# Rezoning Transportation Analysis

Petition Number: 2022-160

**From: Jake Carpenter, PE**  
Jacob.carpenter@charlottenc.gov  
980-221-5675

Date	Description
02-23-23	First Review (PDM)

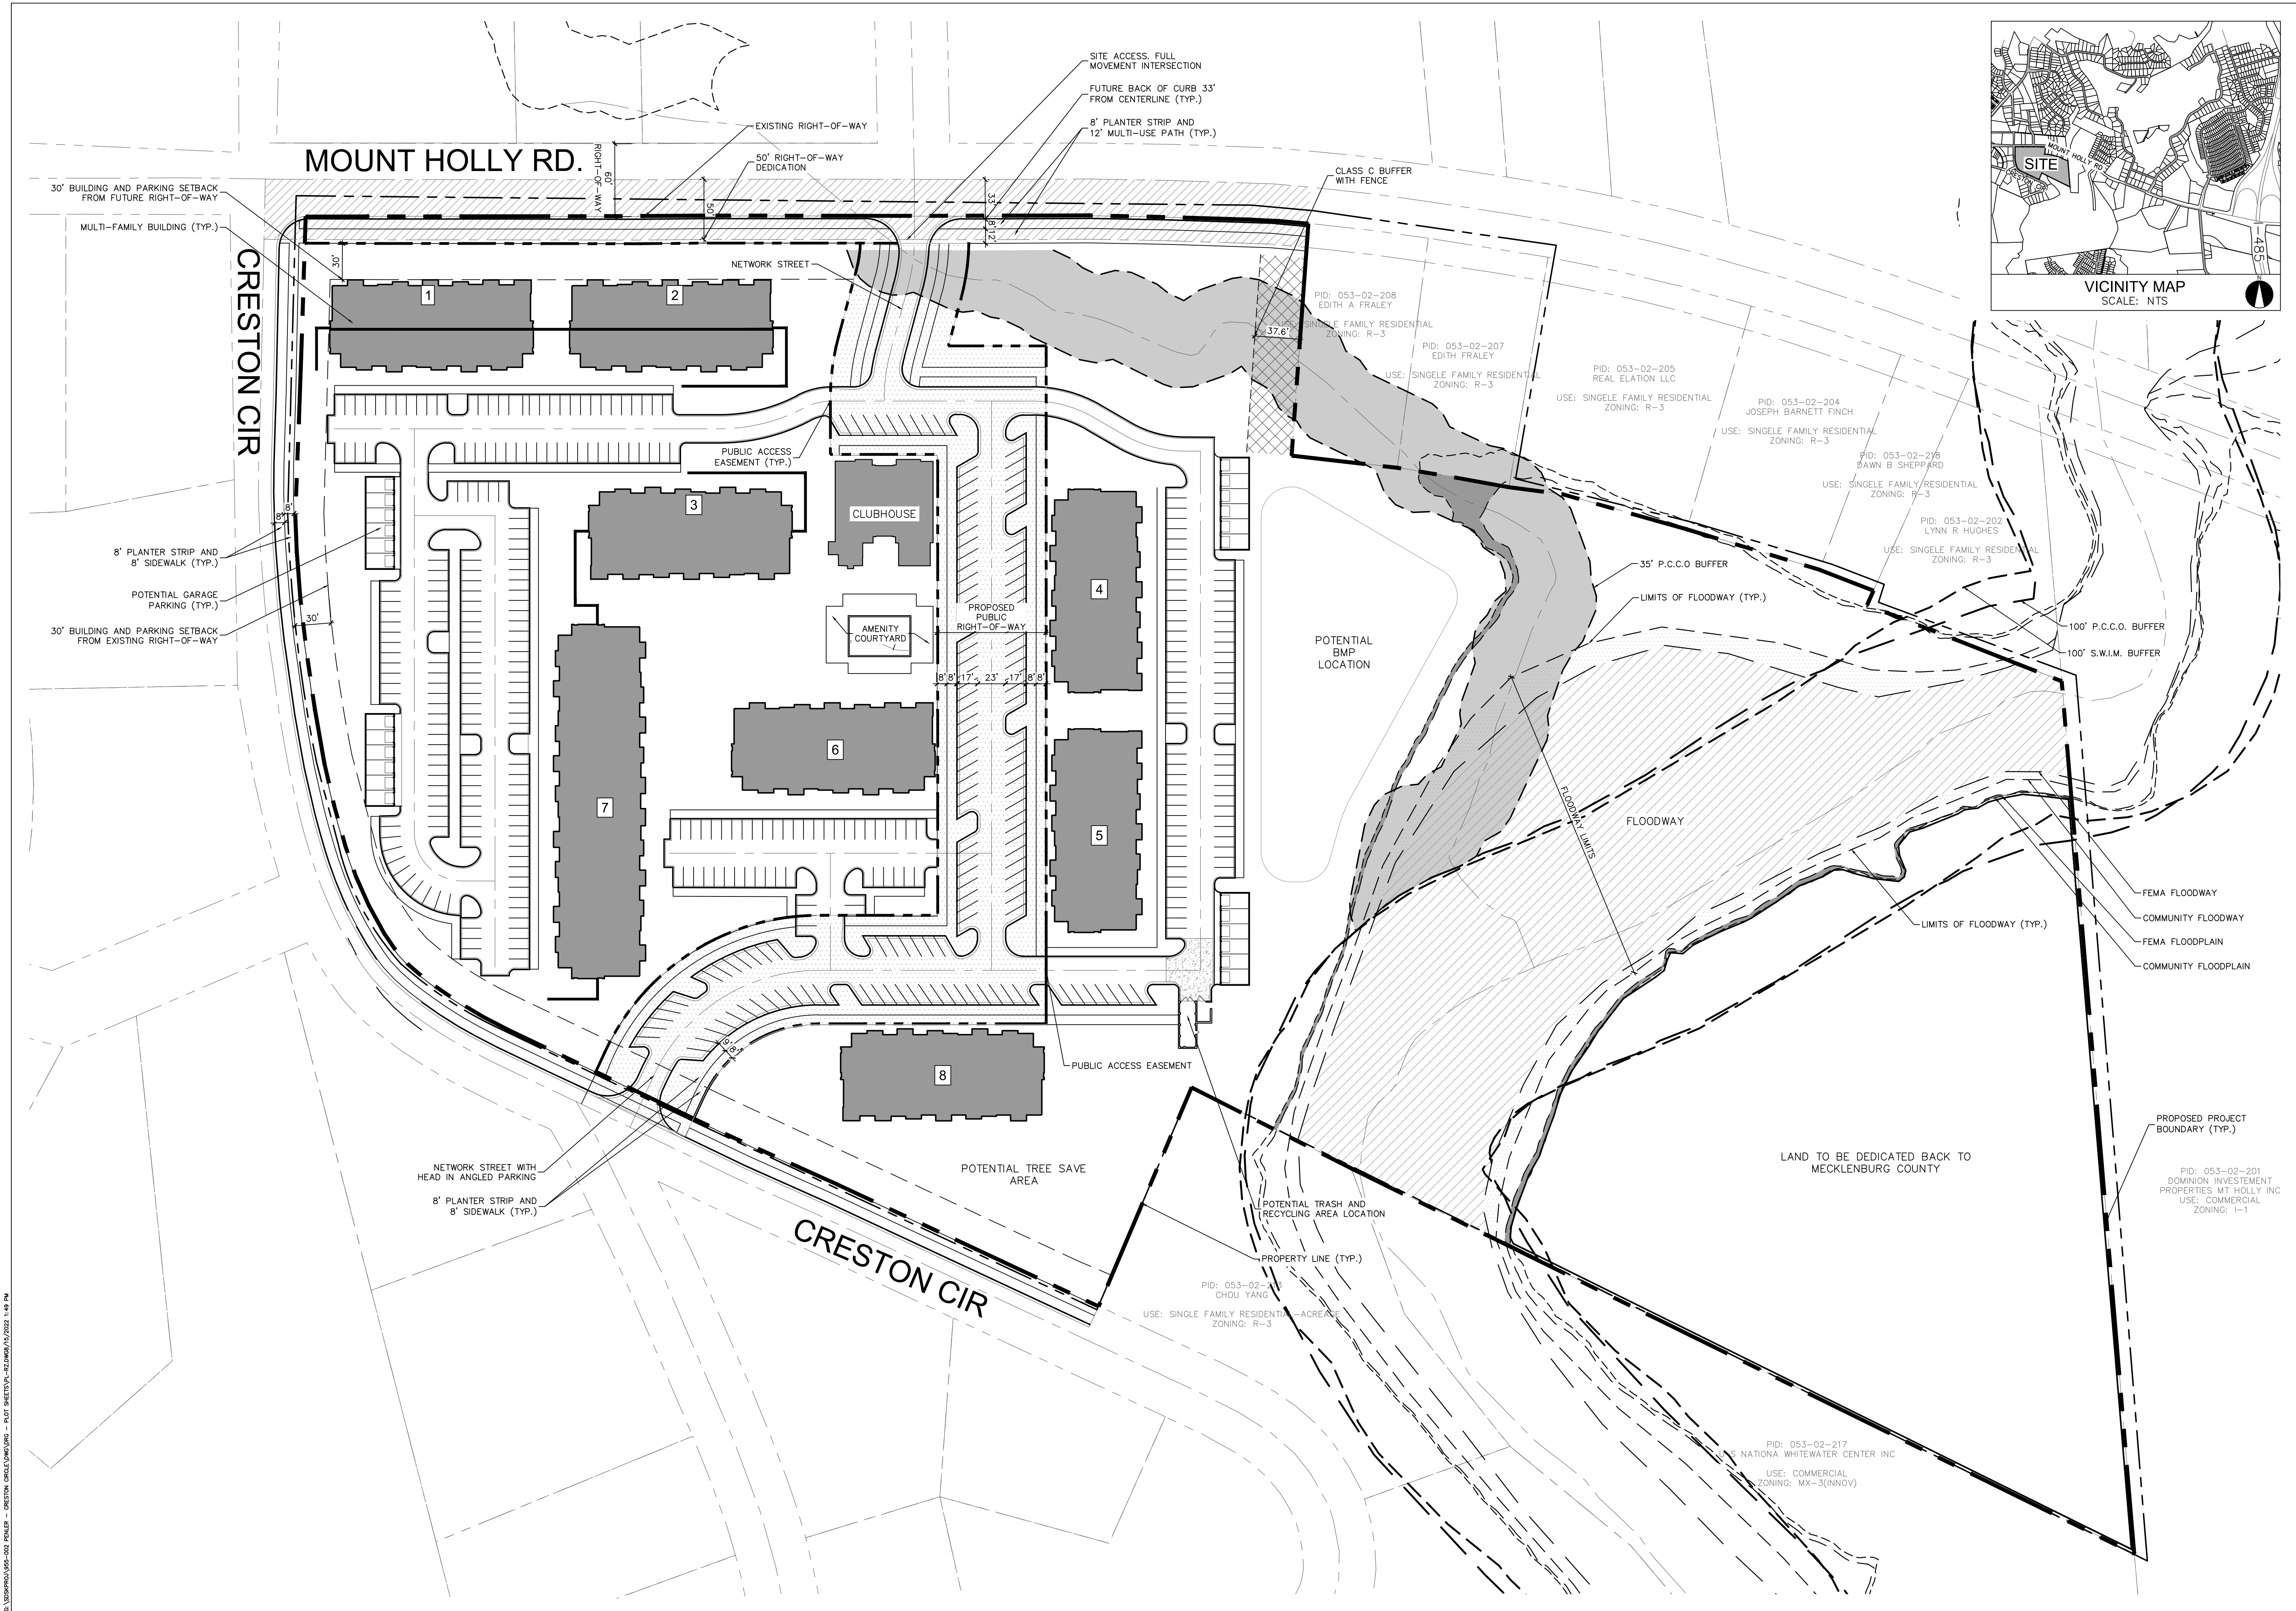
- a. **Mount Holly Road:** Location of curb and gutter to be installed at 33 feet from roadway centerline to accommodate the Charlotte Streets Map roadway typical section of a four plus lane avenue with shared use path.

- b. **Creston Road:** Location of curb and gutter to be installed at 17.5 feet from roadway centerline in accordance with the Local Residential Wide typical section (CLDSM U-03).

Label and dimension the curb and gutter from the centerline for each road on the site plan.

3. Revise site plan and conditional note(s) to label and dimension the existing ROW on Creston Road. Provide a minimum of 26-feet of right-of-way from the road centerline on Creston Road if it does not exist. The site plan shall label and dimension the right-of-way from the road centerline.

4. Per coordination with NCDOT, revise site plan and conditional notes to commit to upgrading Creston Road to meet minimum NCDOT standards from Mount Holly to the proposed site access. Reconcile conditional note 3.e to reflect a Local Residential Wide typical section (CLDSM U-03) or equivalent NCDOT standard.

5. Per coordination with NCDOT, provide a westbound 150-foot left turn lane and an eastbound 100-foot right turn lane on Mount Holly Road at the proposed site access. An eastbound left turn lane on Mount Holly should also be provided to meet intersection geometry requirements for the intersection. In addition, it is recommended that the proposed driveway location is analyzed for intersection sight distance requirements.

6. Per coordination with NCDOT and Subdivision, revise the proposed public street to meet NCDOT standards if the site will not be annexed into the City, or revise road to be a private street with a public access easement. If the site will be annexed into the City and the road is to remain public, the road will need to be realigned to meet CDOT standards and the angled parking will need to be removed.

9. If site is to remain in the ETJ: Revise site plan and conditional note(s) to construct an 8-foot sidewalk on Creston Road and a 12-foot multi-use path on Mount Holly Road. The site plan shall label and dimension both items from the back of curb and gutter or edge of pavement, and the facilities should be located outside of the ROW. Add conditional note that the entire facility must be outside of the right of way and within a public access easement. Add conditional note committing to construction and maintenance of the 8-foot sidewalks and 12-foot multi-use paths.
